CITY OF ALBUQUERQUE

August 3, 2012

Re: Bruckner Truck Sales, Inc., Drainage Report and Grading Plan
Engineer's Stamp dated: 7/19/12 (J09/D021)

INLET CAPACITY - STORM INLET 2

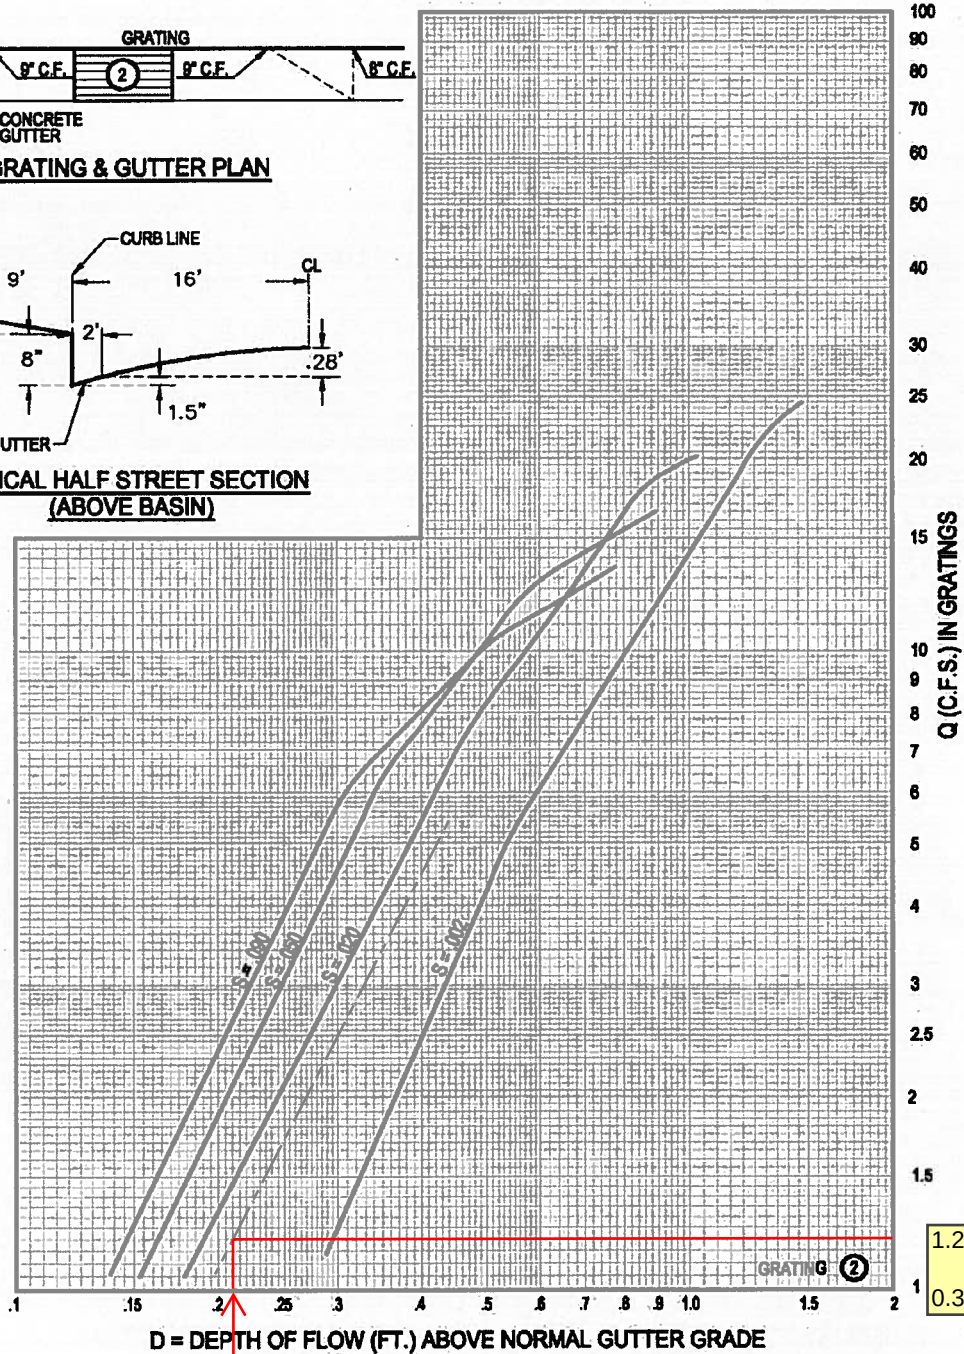
- Include inlet capacity calculations.
- Provide street flow capacity analysis and inlet capacity analysis for Daytona Rd.
- Please provide erosion and scour analysis passed the enclosed riprap for the channel. Would scour wall be required at the end of the riprap?
- What is the status of plugging the 48" storm drain pipe on the north side of the I-40?
